Your Ref: OWPC5200
Our Ref: A/10/15/PL 28-01-2015
Please ask for:
Mrs A Gardner

2 No. detached houses with garages. This is a Departure from the Development Plan.
Land at West Drive Ham Manor Estate Angmering

Re Application A/10/15/PL

Objection to Planning Application A/10/15/PL

ELEVATIONS
PLOT 1

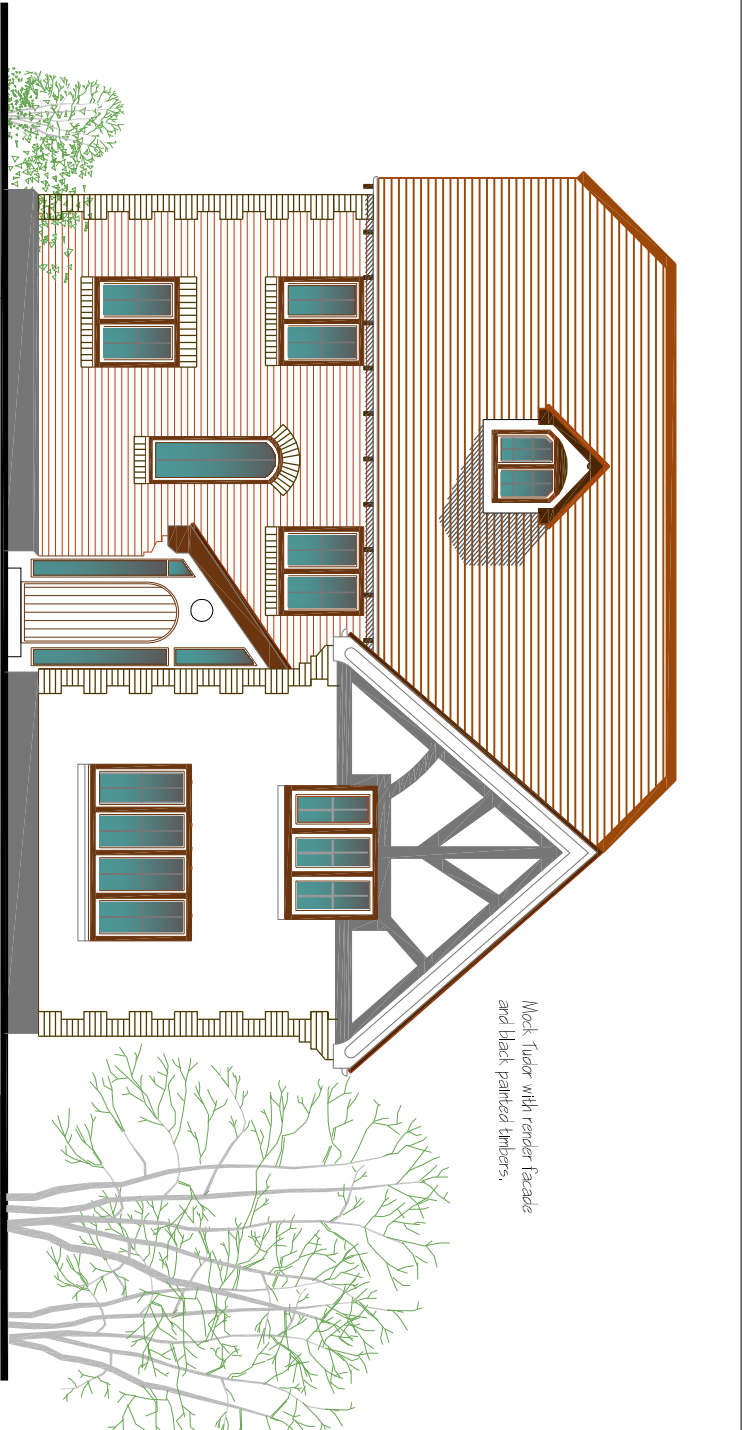
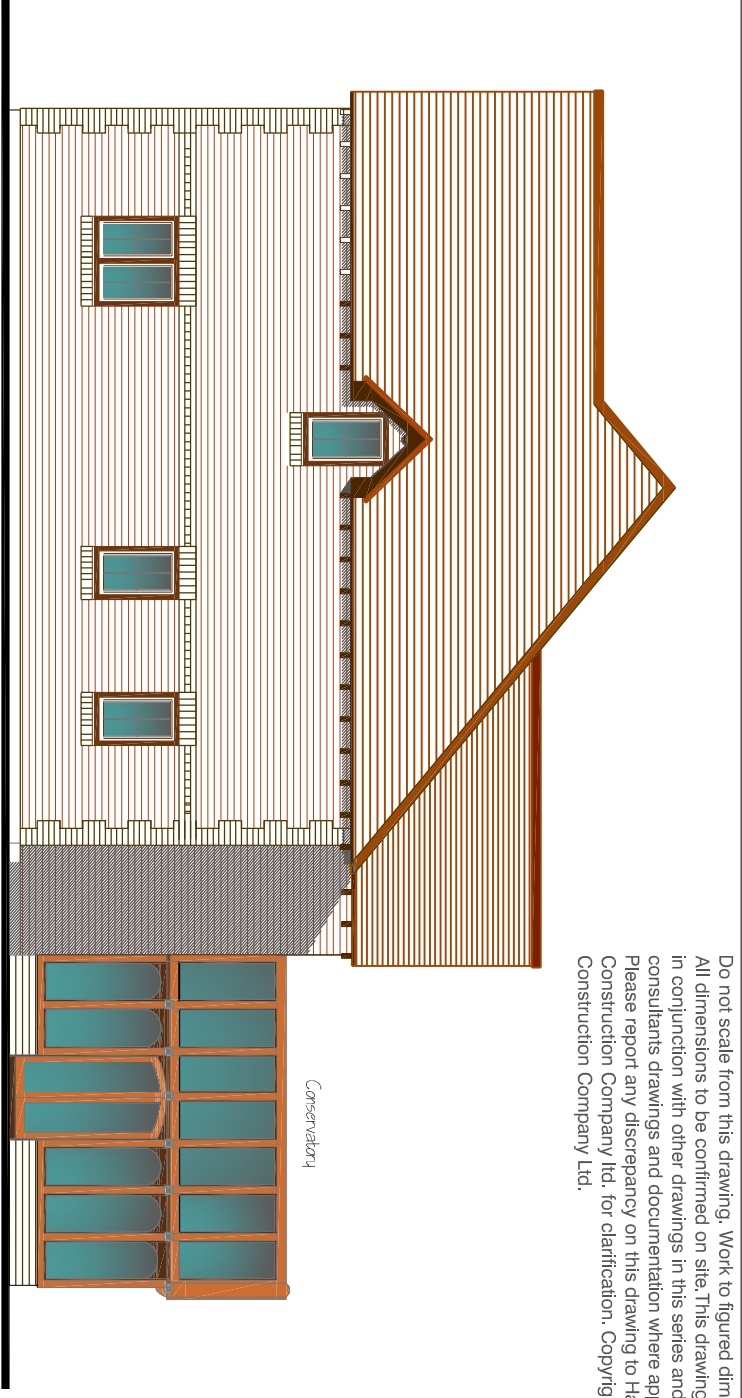
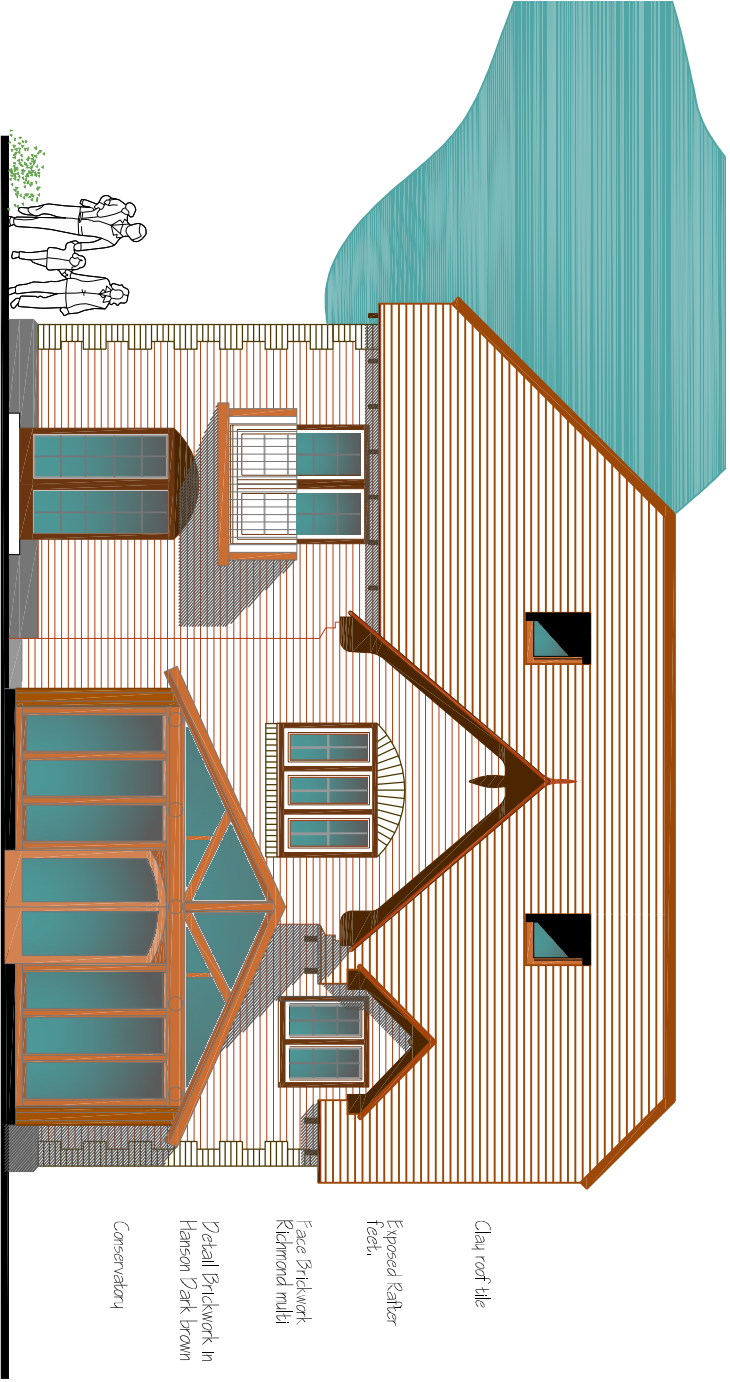
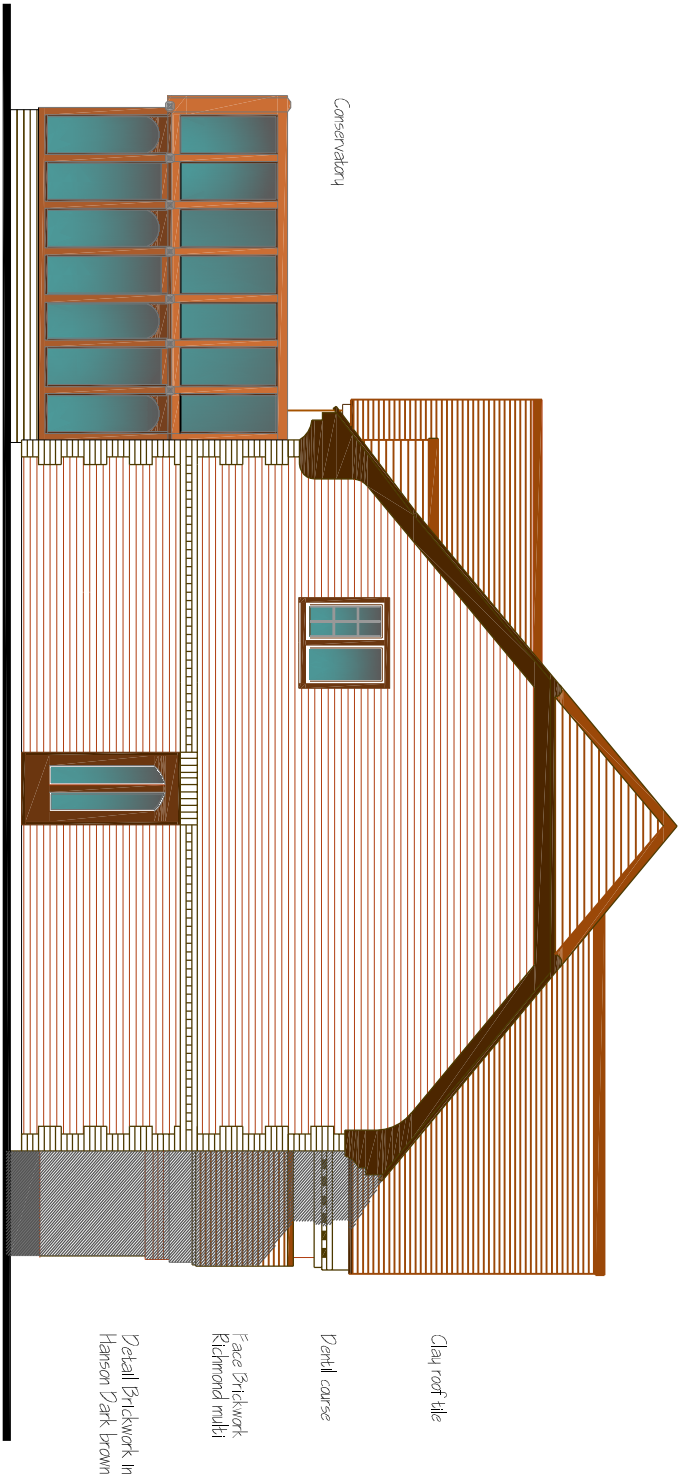
The application is for the erection of two dwellings on a site for which permission was previously granted under reference A/190/06. While the number of dwellings remains at two with substantially the same 'foot print', the design has altered with a more prominent roofline profile; and, the use of the roof area as habitable space with the addition of dormer windows, presenting in effect 2 1/2 storey buildings.

In our view the design as revised from that subject to the 2006 approval, is out of keeping with the neighbourhood area, where houses are exclusively of two storeys. The erection of homes with additional living space in the roofs, effectively 2 1/2 storeys, with attendant impact on our own property, would be wholly inappropriate.

Front Elevation (North) Plot 2

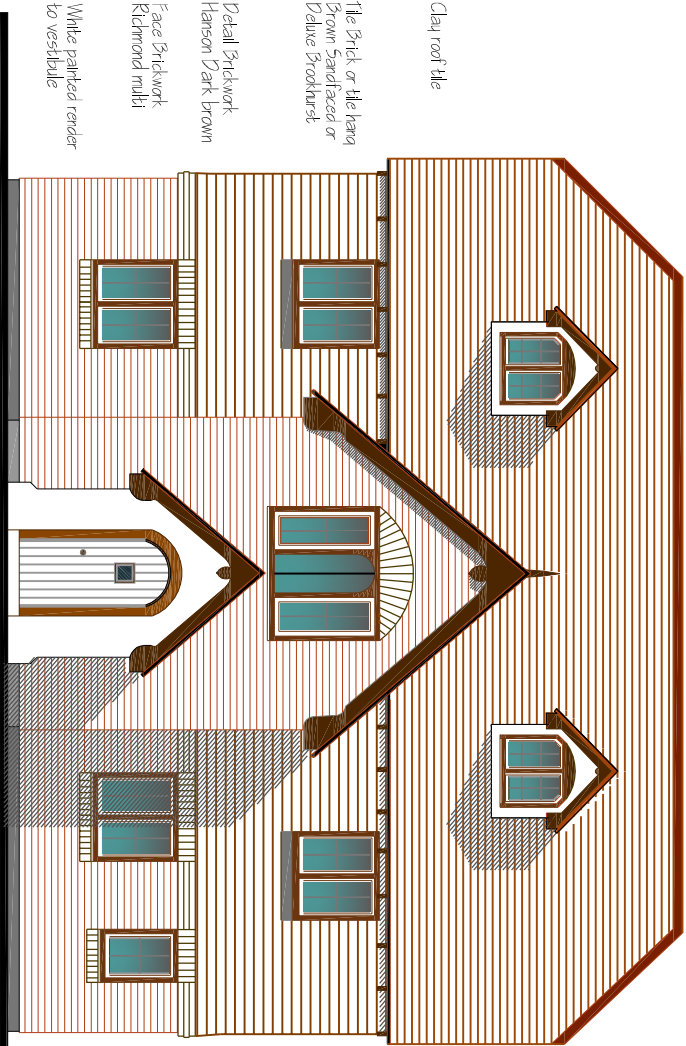
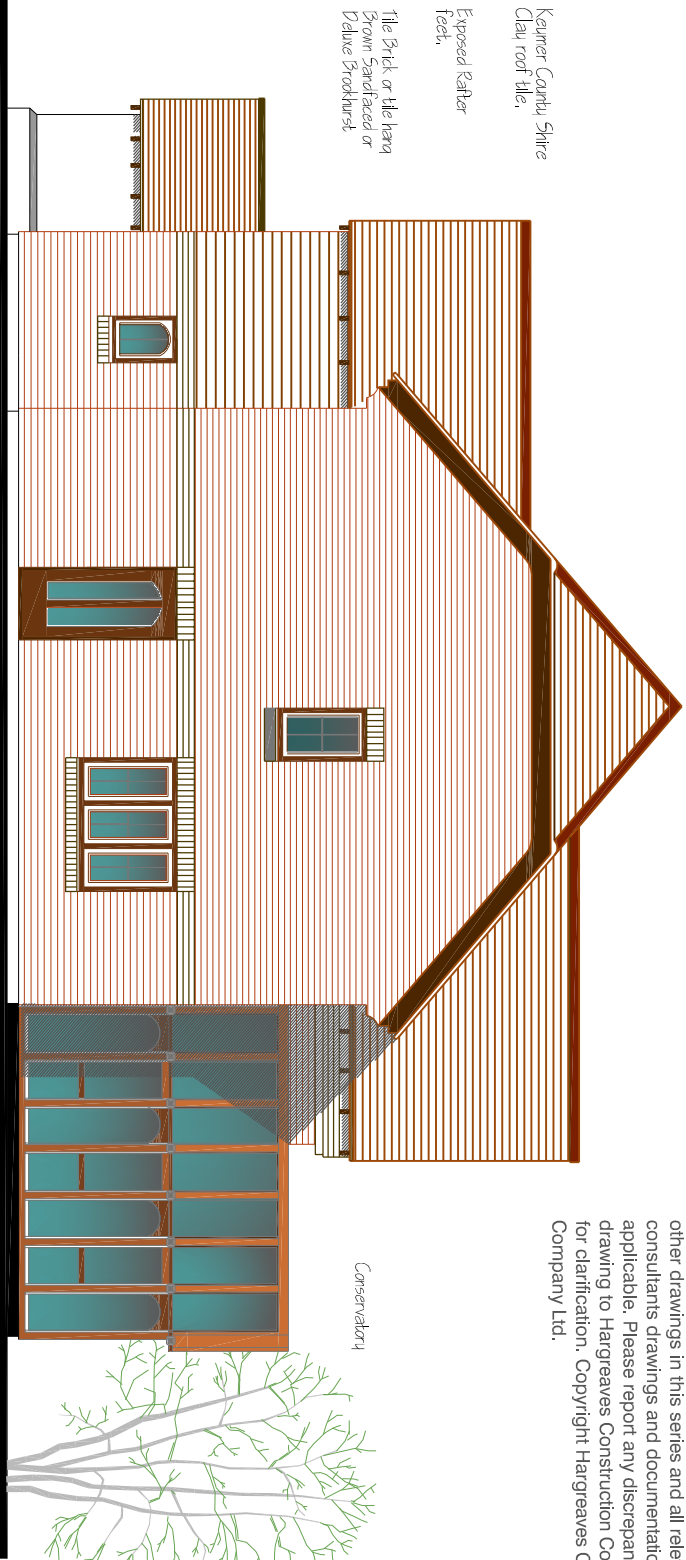
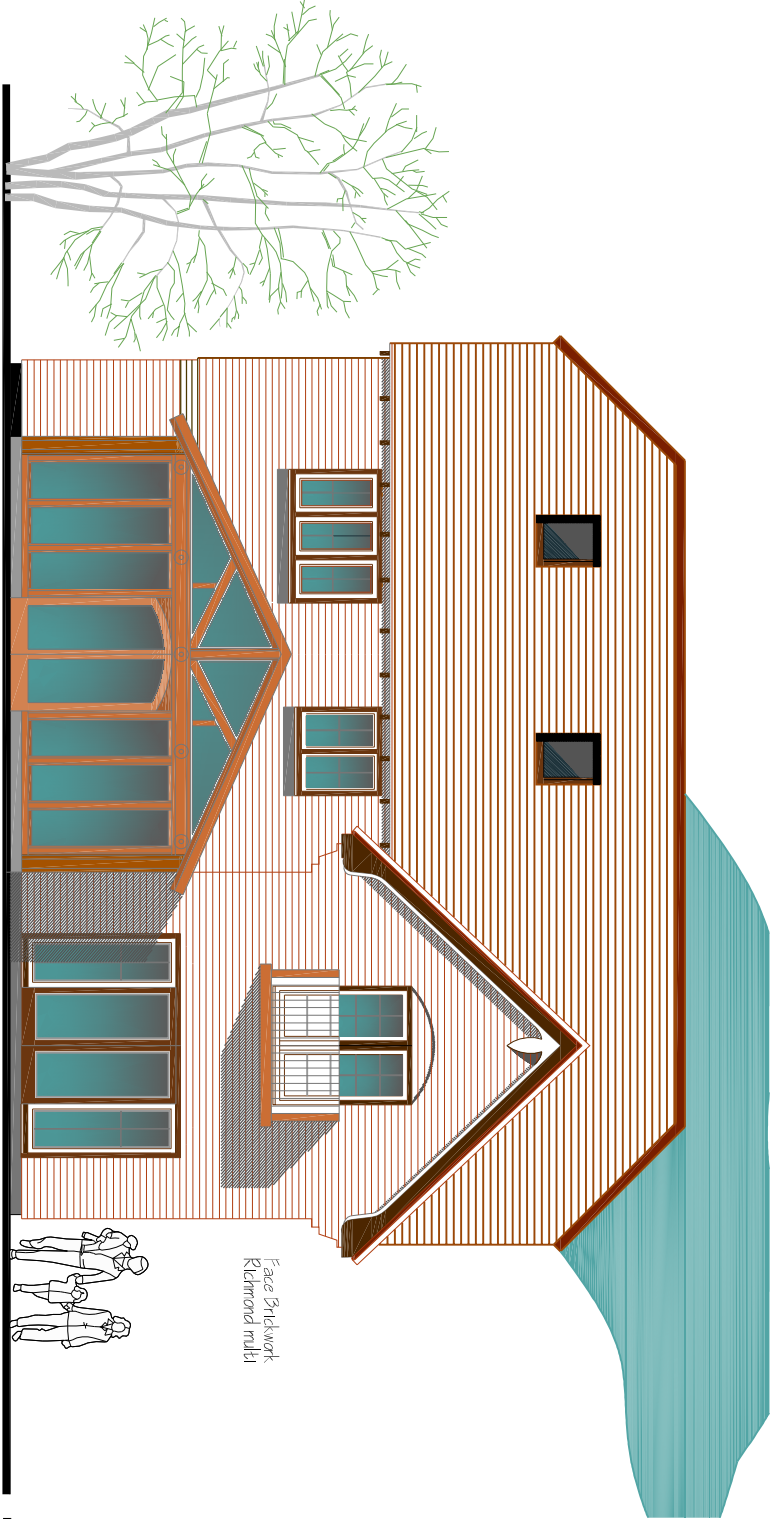
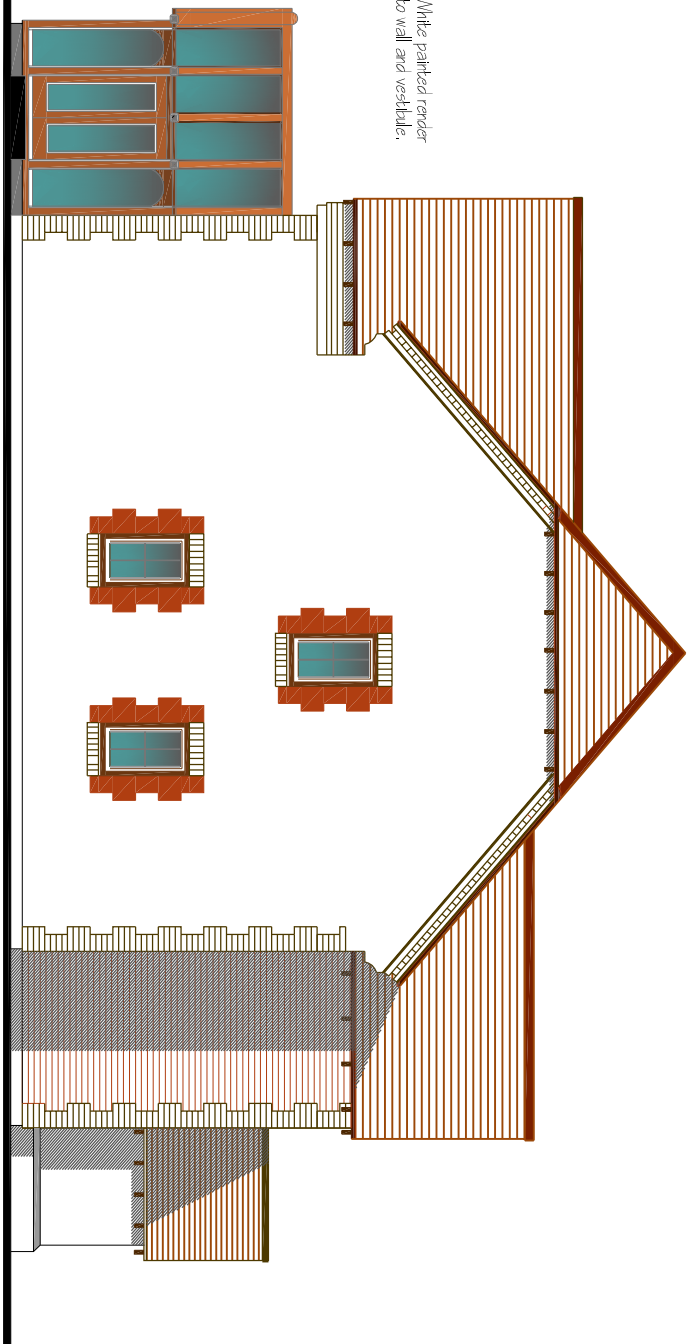
As presented on the application plans, the houses have a north/south aspect, with both of them, but particularly Plot 2, facing directly on to our own property. The combination of the plot elevation with the overall height of the houses will result in the roof dormers overlooking our home and depriving us of reasonable privacy in our upper storey bedrooms. In addition, this combination of proposed roof design/height and the elevation of the site will serve to overpower the adjacent properties particularly those situate on the eastern edge of West Drive.
